Reference: PR-2024-010951 aka PR-2024-010617 SP-2025-00061 – SITE PLAN DFT Civil Engineering Comment Response

All or a portion of: Lot/Tract 165, TOWN OF ATRISCO GRANT AIRPORT UNIT zoned MX-M, MX-L, located at 724 64TH ST NW. (J-10)

REQUEST: Site Plan Administrative Approval of Phase 1 of the development to be known as West Mesa Ridge. This is a 128-unit workforce housing multifamily residential development to be constructed with partial funding from the City of Albuquerque. We are requesting approval of the Infrastructure List for Phase One in this application as well

U1.2

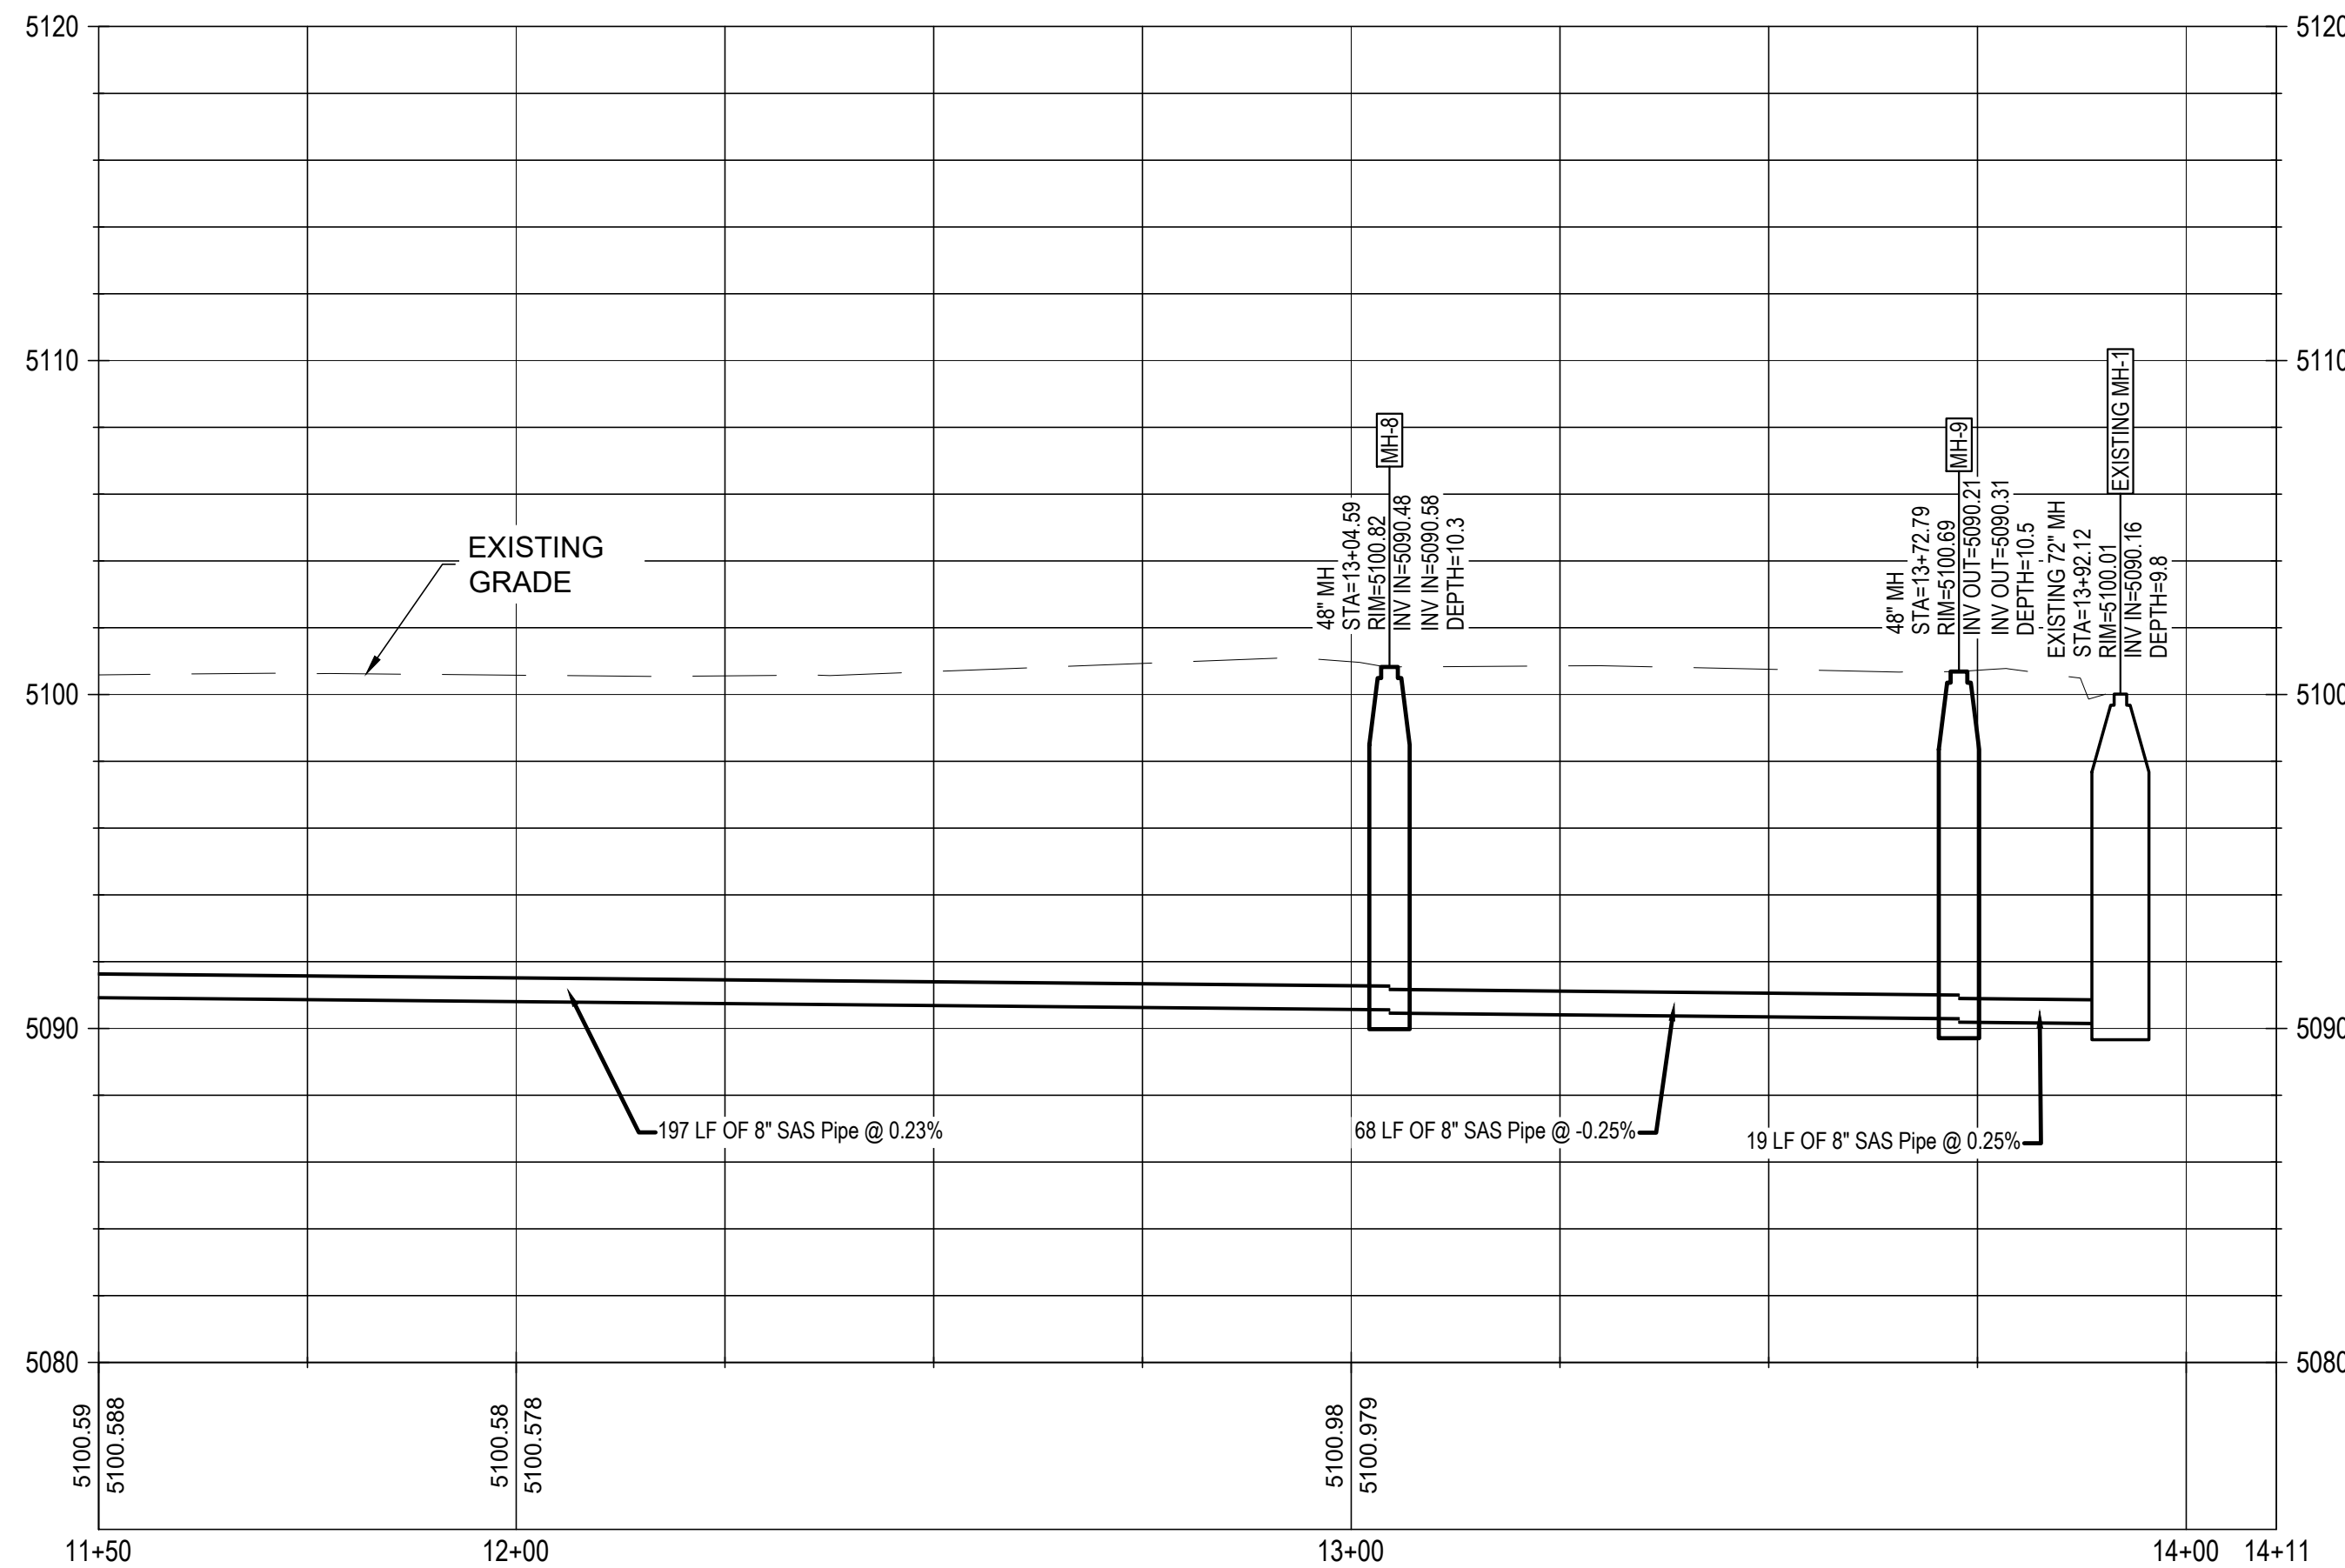
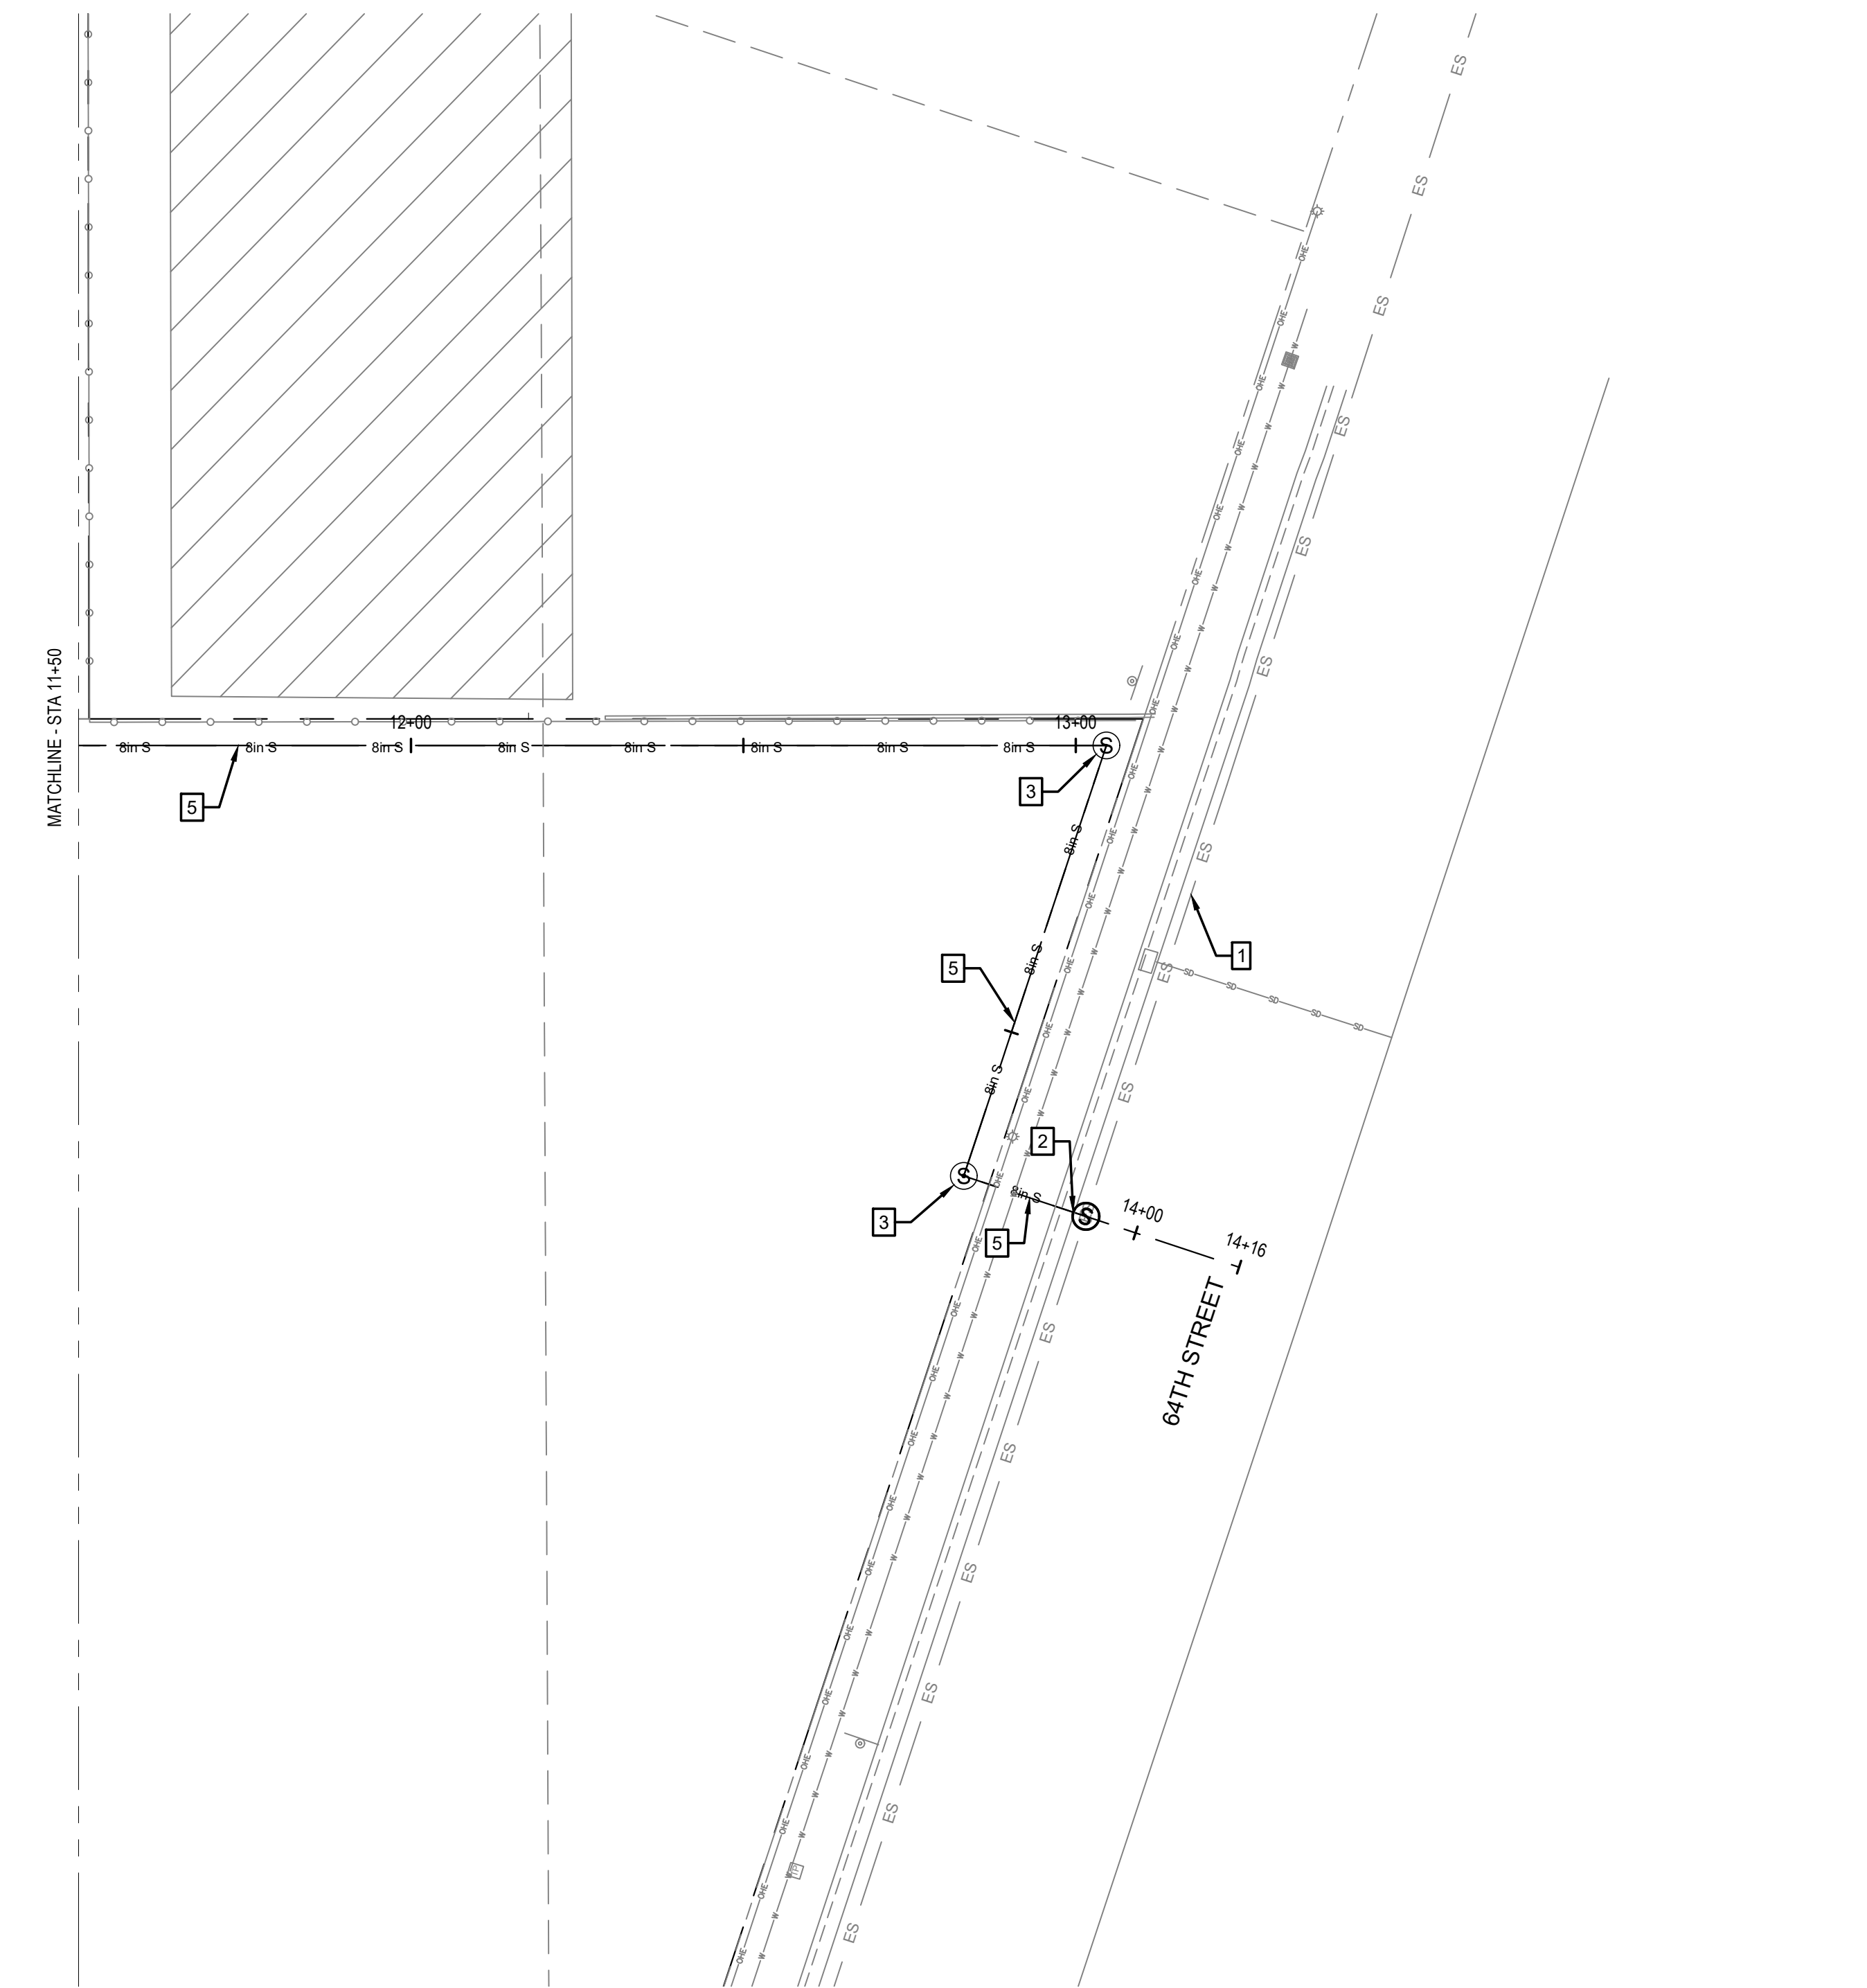
- a. Provide a utility plan that indicates the location of proposed services.

- b. Show existing public water and public sewer mains and any associated easements on the utility plan.

- c. Dimension the public water and public sewer easements on the utility plan.

- d. There shall be no trees, parallel fences/sidewalks/curbs, or structures within the public water and public sewer easement. Please revise accordingly.

- e. Please add the following notes to the Master Utility Plan

- i. Coordination with Water Authority Cross Connection Section will be required to ensure proper backflow containment is in place prior to release of meter for the site. Contact the Cross Connection Section at 505-289-3454.
- ii. Coordination with the Water Authority Pre-Treatment Engineer is required to ensure the site complies with Water Authority Sewer Use Ordinance. Contact the Pre-Treatment Engineer at 505-289-3439.

RESPONSE: See attached utility plan for proposed service locations.

RESPONSE: See attached utility plan for existing and proposed public water and sewer mains.

RESPONSE: See attached updated utility plan for dimensioned public utility easements.

RESPONSE: See attached updated utility plan for easements outside of fences, trees, curb and gutter, and structures.

RESPONSE: The above notes have been added to the attached updated Utility Plan.
